**KIRKLEES METROPOLITAN COUNCIL
INVESTMENT & REGENERATION SERVICE**

DELEGATED DECISION TO DETERMINE APPLICATIONS FOR LISTED BUILDING CONSENT

Reference No:	2025/65/92733/E
Site Address:	Grange Cottage, Kirkby Grange Farm, Clough Road, Flockton, Huddersfield, WF4 4AQ
Description:	Listed Building Consent for replacement windows, installation of rooflights, alterations to chimney and associated works
Recommending Officer:	Elenya Jackson

ground floor plan

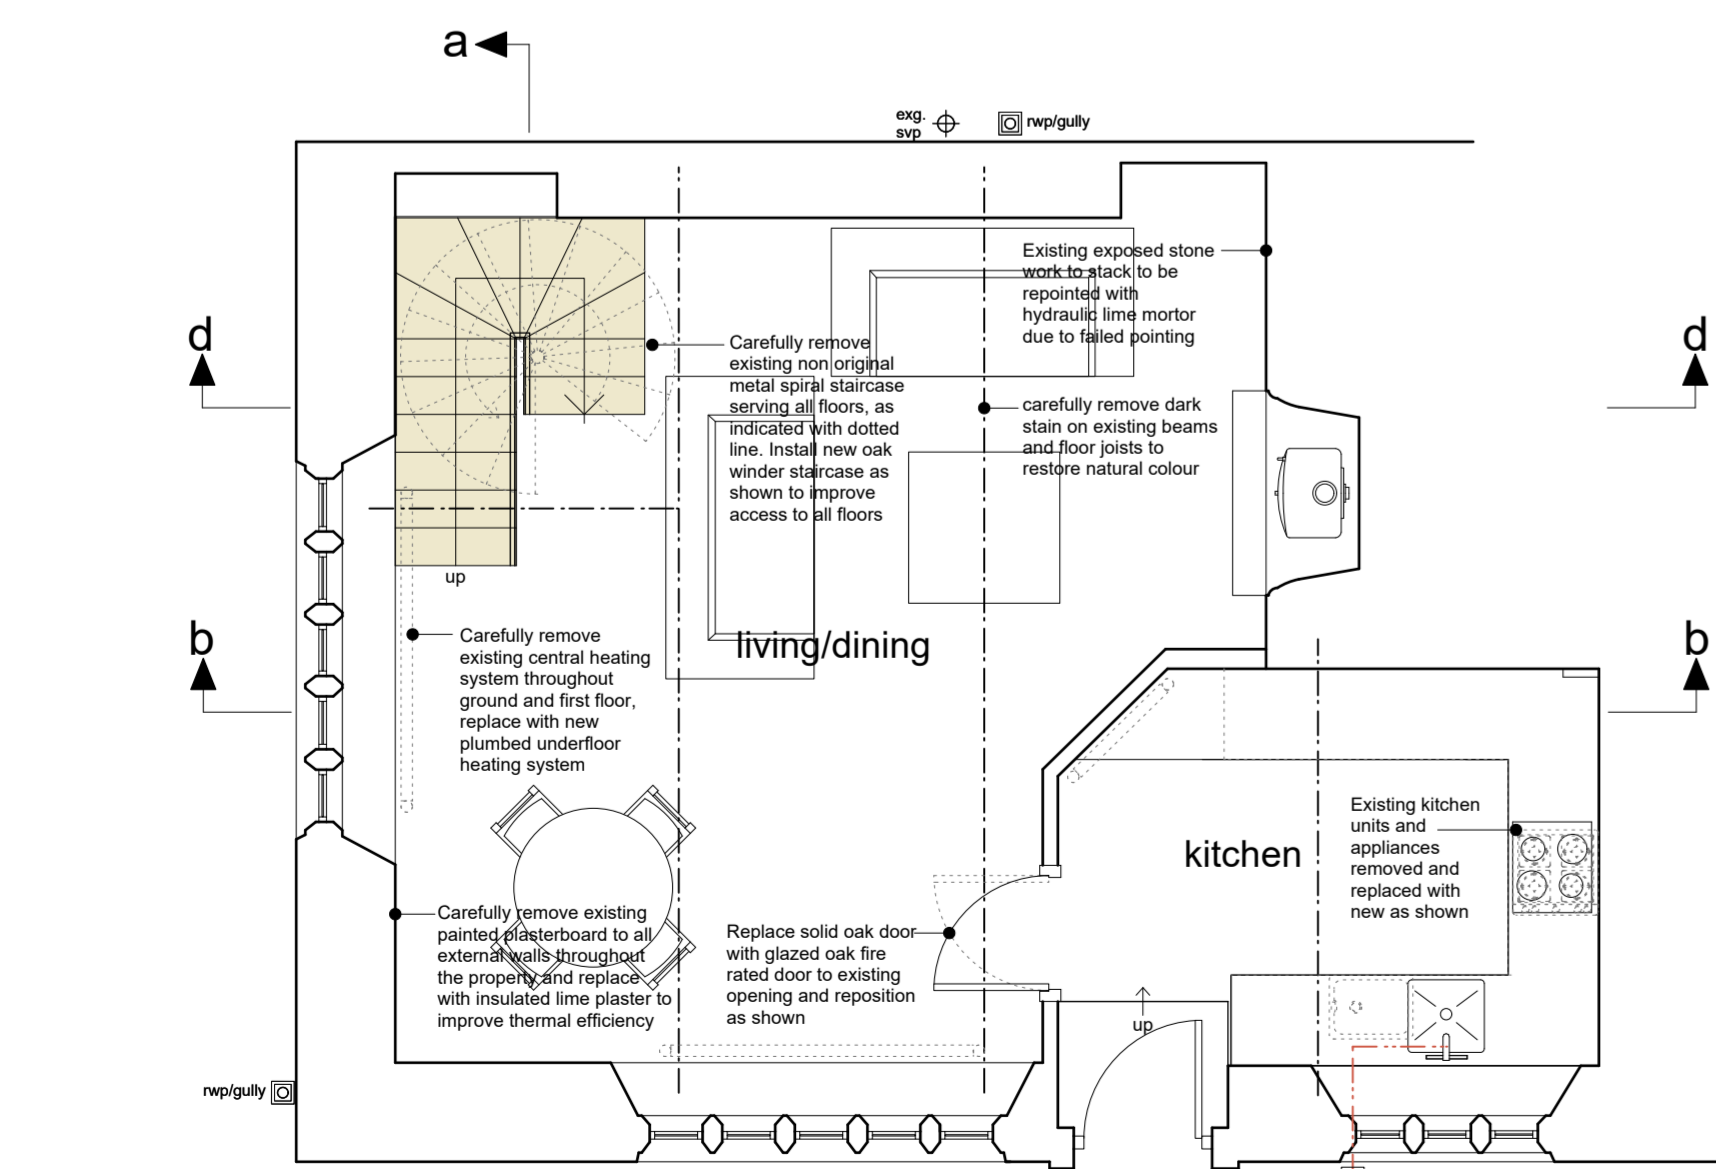
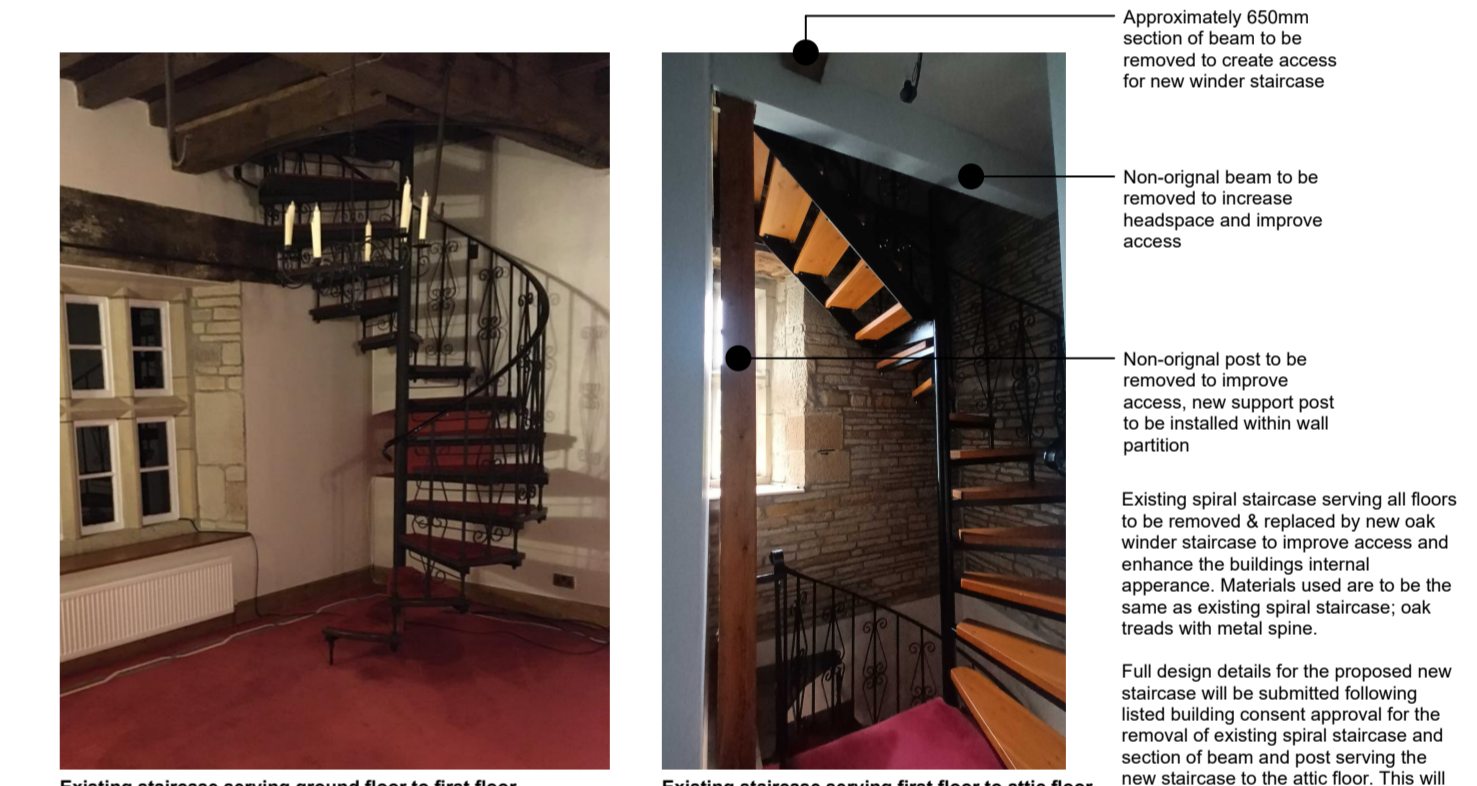
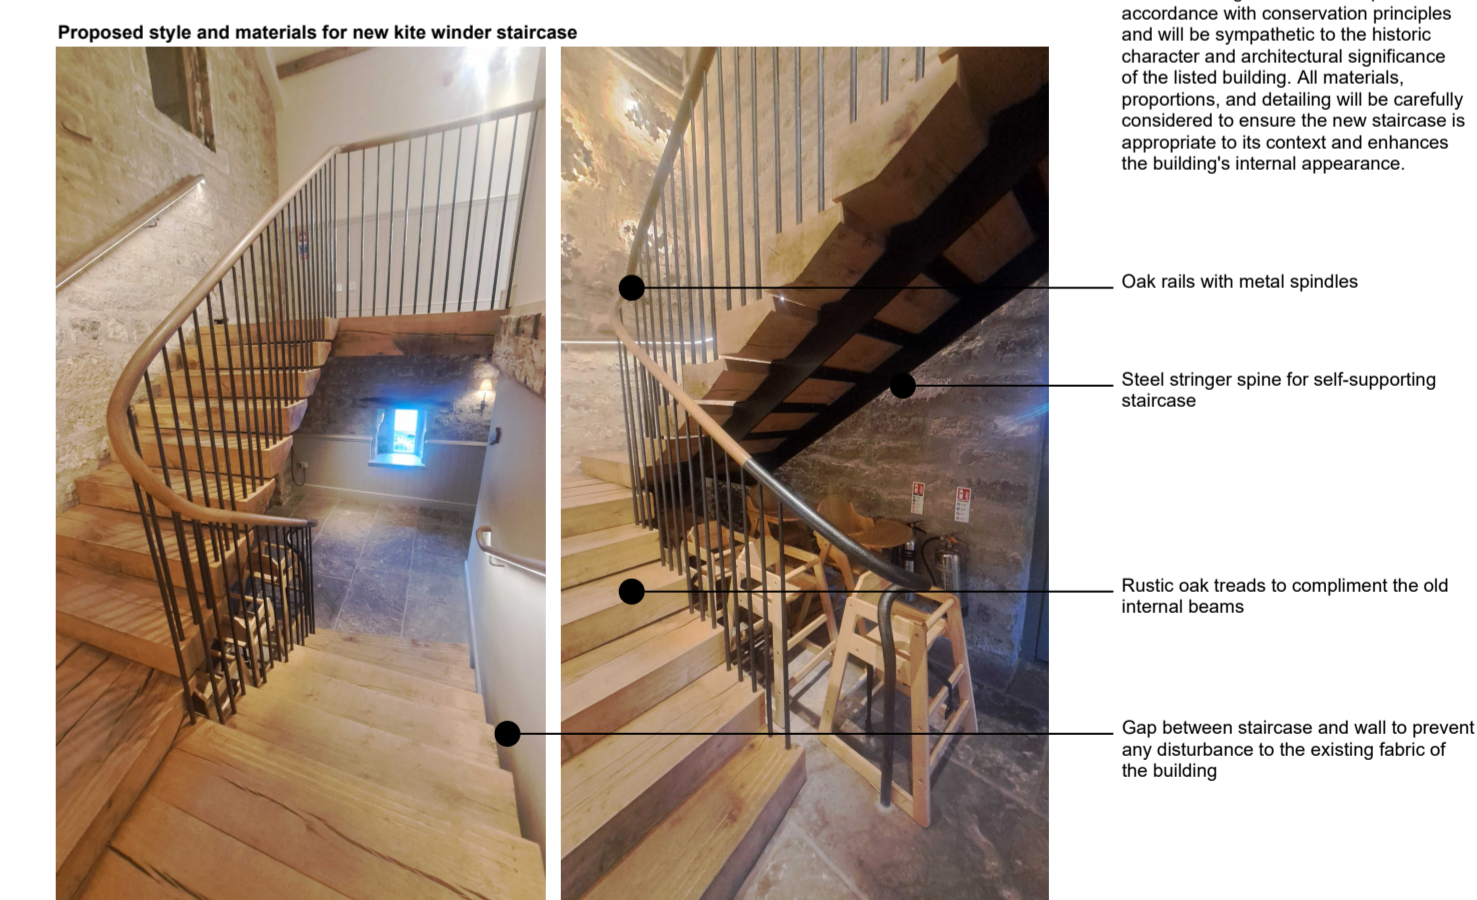
During the course of the application, alterations were requested to reduce the number of roof lights, amend the doors to be more in keeping with the historic character and change to proposed staircase to feature less glazing..

KC Conservation & Design (informal) – The Conservation & Design Team requested alterations to the design of the proposal which sought reductions to the number of roof lights, alterations to the internal staircase, alterations to the internal doors. Amended plans have been provided and the application has been progressed on this basis.

5. Notwithstanding the submitted details, details of the proposed staircase are to be submitted and agreed by the Local Planning Authority prior to installation.
